**Consultation Response from KC,
Highways Development Management**

2024/91497 Land at, Yew Tree Road, Birchencliffe, Huddersfield, HD2 2EQ

Discharge conditions 2 (materials), 4 (highways), 7 (landscape), 8 and 9 (bin stores), 10 (crime prevention), 11 (boundary), 12 (lighting), 16 (highway structures) on previous permission 2021/94363 for reserved matters application pursuant to outline permission 2018/90151 for erection of 17 dwellings

TITLE
Construction Plan

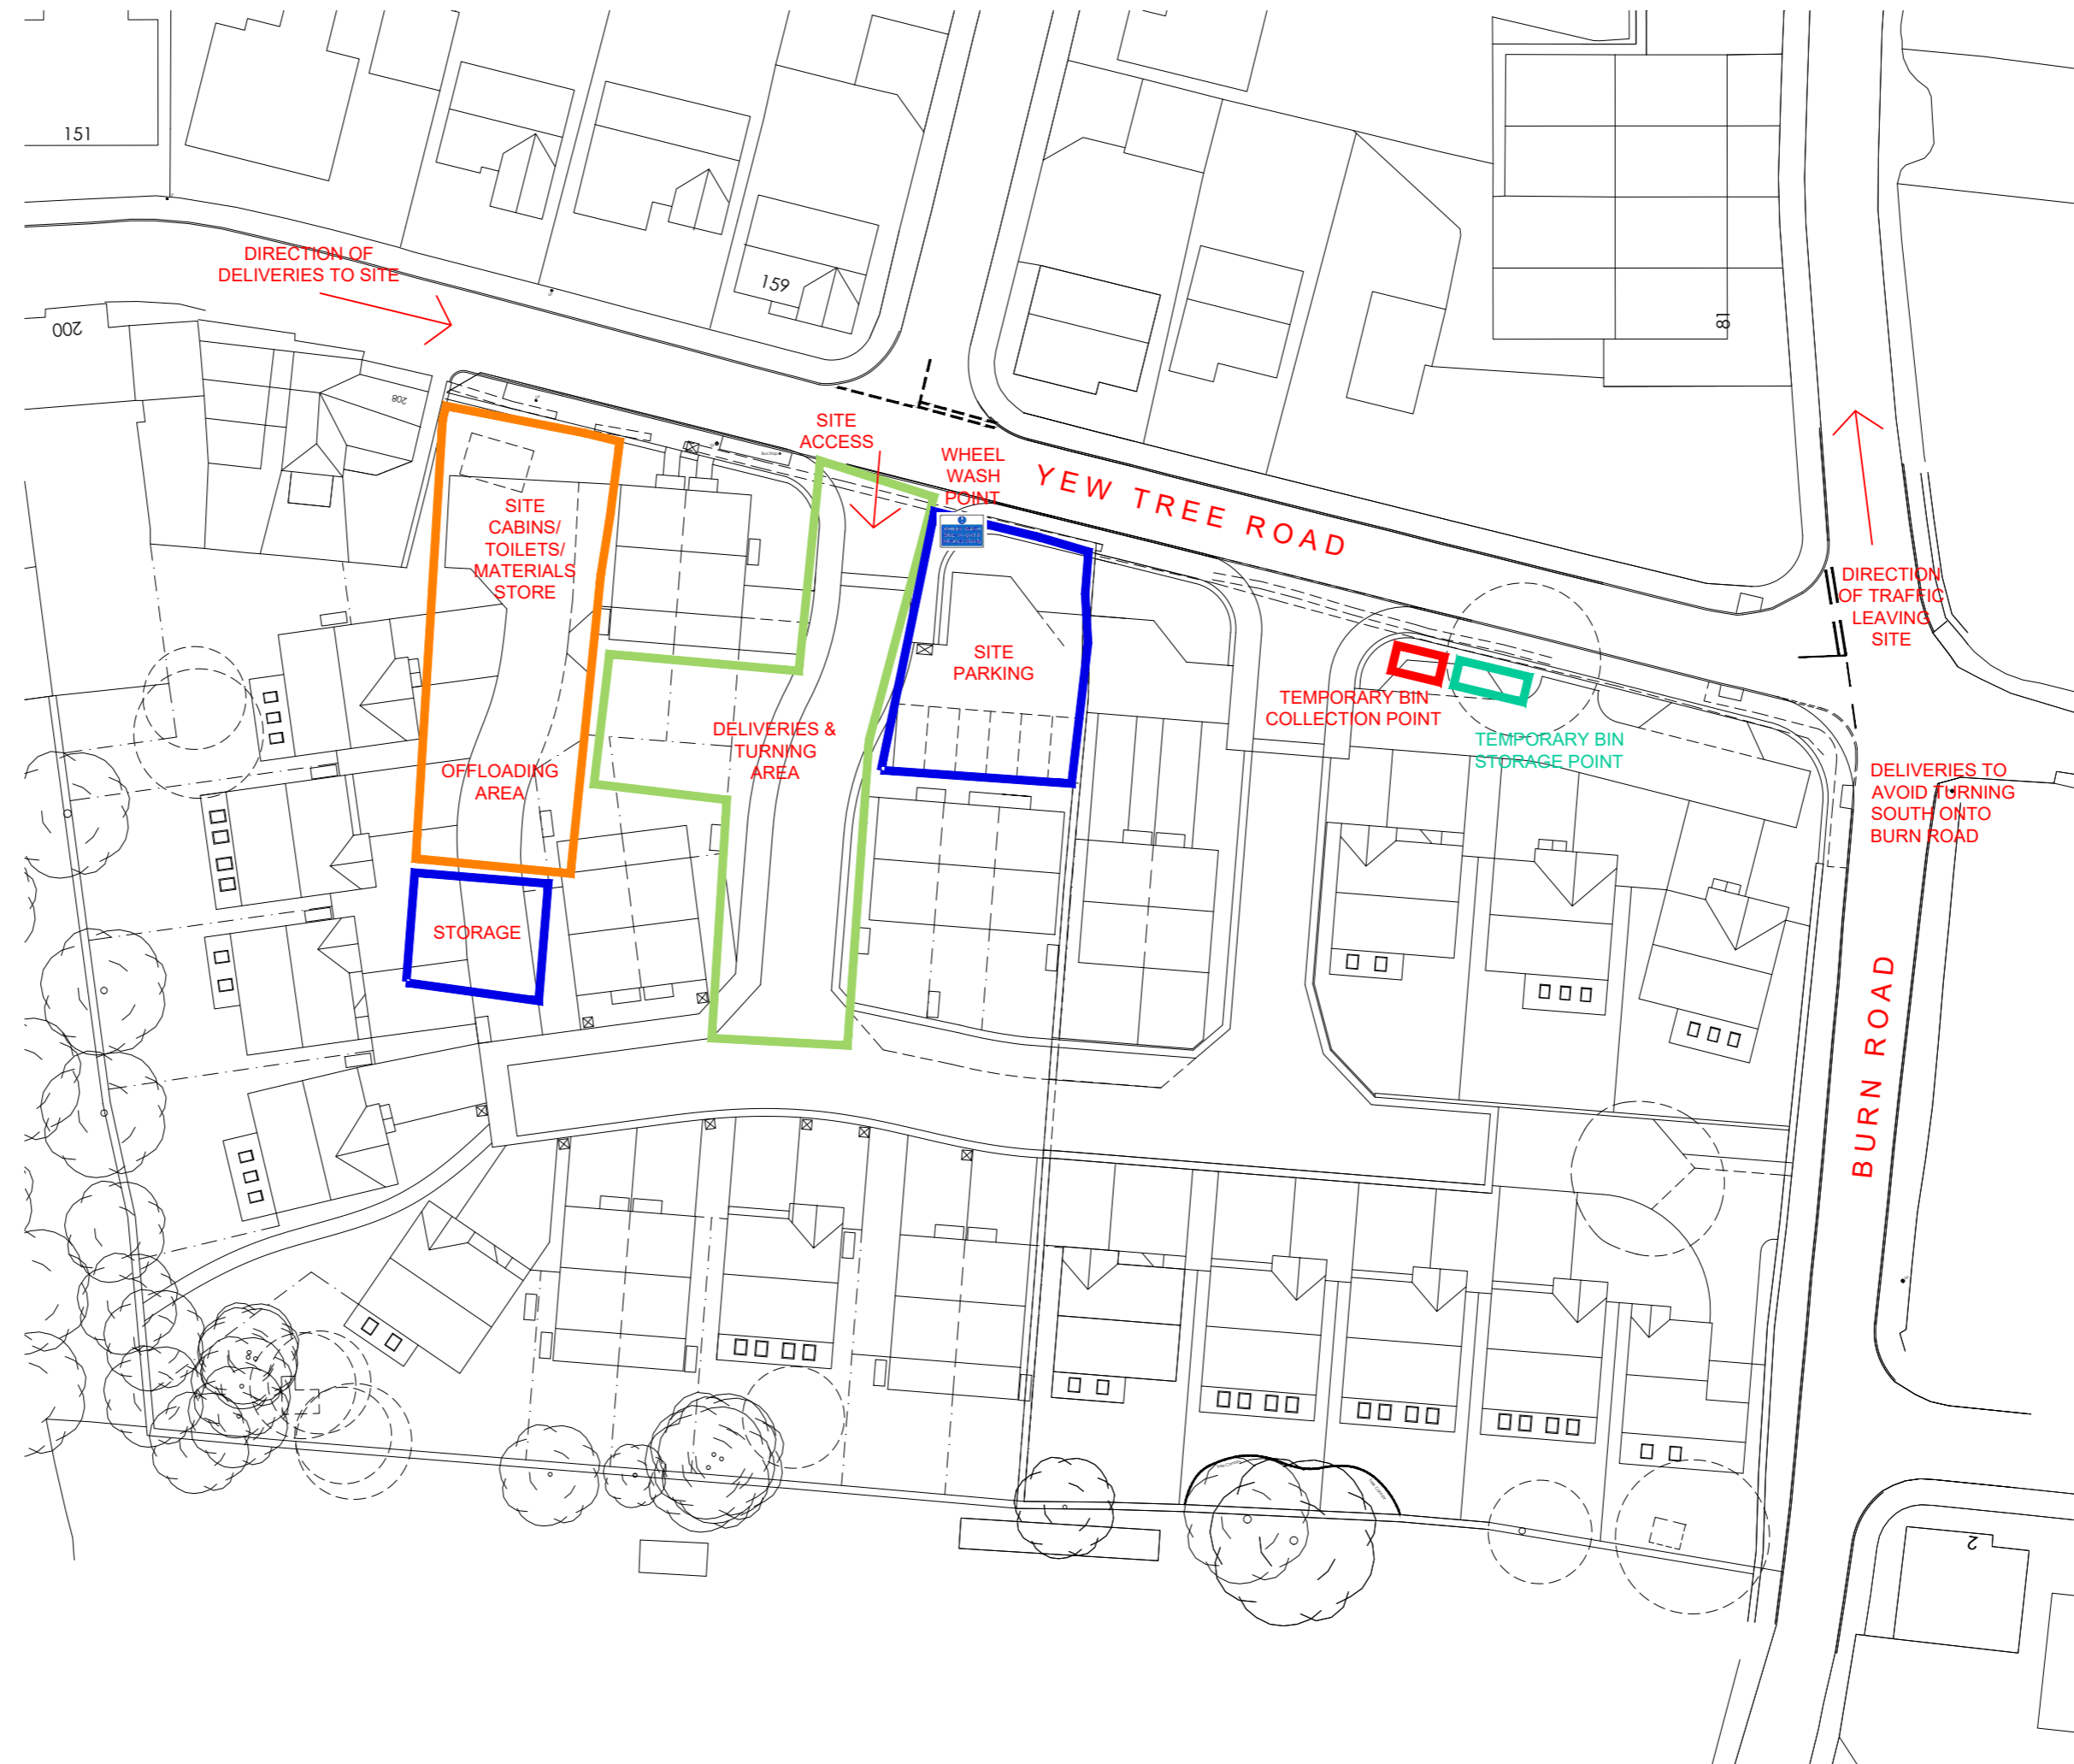
Notes on the Construction Plan state that wheel washing will be positioned within the site entrance to remove any site contaminants from vehicles prior to accessing the public highway. The Site Manager will monitor the condition of the site access and public highway throughout the working day.

The Construction Plan does not mention the provision of road sweeping and this condition should not therefore be discharged.
